Planning Application Ref: A/132/19/DOC

Location: Merry England Nursery, Dappers Lane, Angmering, BN16 4EN

Description of works: Approval of details reserved by condition imposed under ref A/91/18/PL relating to Condition Nos 4 - surface water drainage, 6 - flows to watercourses, 7 - SuDs system, maintenance of any watercourse, 11 - Construction Management Plan, 12 - road safety audit, 14 - ecological, **17 - tree protection** and 21 contamination

Comments on Application:

Rev	-	
Drawing Title		
Tree Protection Plan		
Client	Date	
GD Group	09.10.19	
Project	Drawing Ref	
Merry England	TPP	
Scale	Drawn	Job Number
1:250@A2	JLD	1909

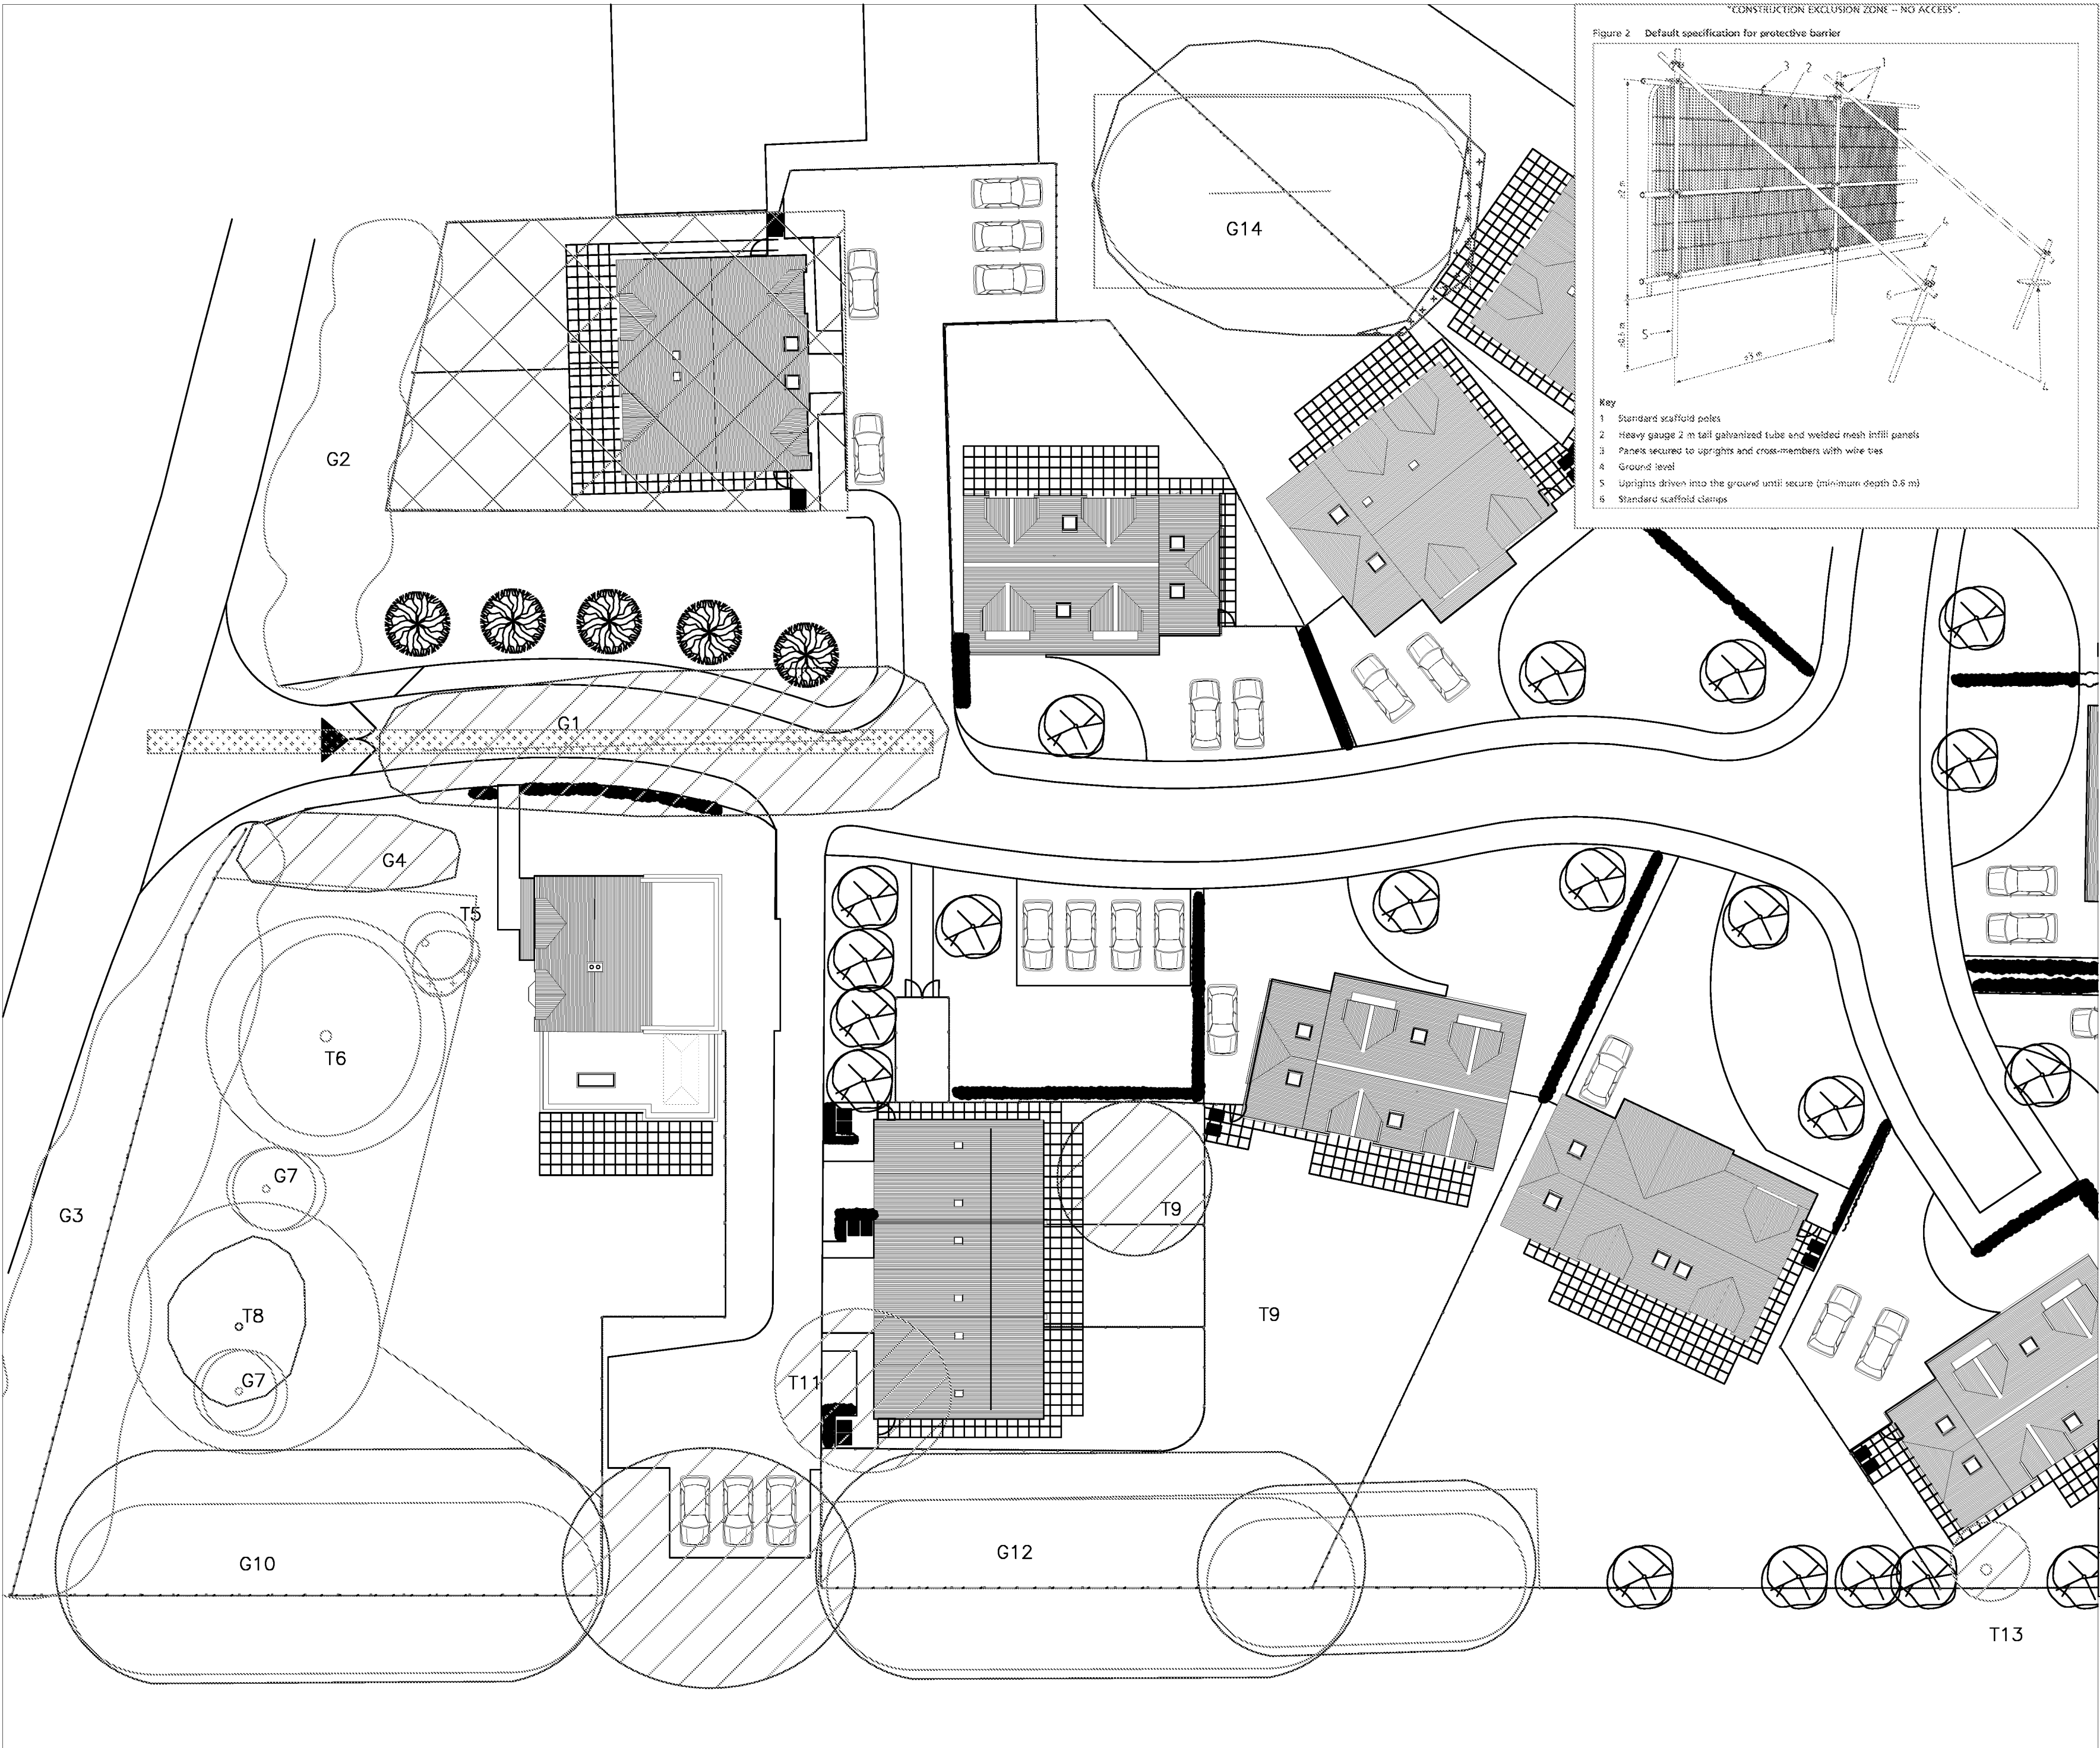
· A pre-commencement Site Meeting is to take place between the Arun DC Tree Officer and the Arboricultural Consultant representing the site owners - at this meeting all protective fencing will be inspected along with ground protection measures - they will be assessed to verify that they are 'Fit for Purpose' as required under British Standard 5837:2012 and have been erected and positioned exactly as shown on the Tree Protection Plan PJC/3928/16/C Rev 01 02/06/2016 1:500 @ A3.

- I have visited site on several occasions with a view to discharging Condition 17. My initial visit occurred on 11th October 2019, with site manager and project arboriculturist in attendance. The bulk of protective fencing was installed correctly and at the appropriate locations, with only a few minor but necessary refinements to take place.
- We walked all areas of the site where tree protection was to be installed, as per the latest **Tree Protection Plan** submitted with this application, from **The Urban Forest Consultancy: Dwg. ref. DTPP, dated 11/09/2019.**
- The above plan correctly shows the position of G1 hornbeam; a substantial revision of earlier illustrations that allowed for their retention. Layout approved at Reserved Matters cannot accommodate those trees. This conflict has been addressed by application A/160/19/NMA.

- The few minor anomalies I observed at the time of my initial inspection have been resolved to my satisfaction.

- **I recommend we now discharge condition 17** under this application reference.
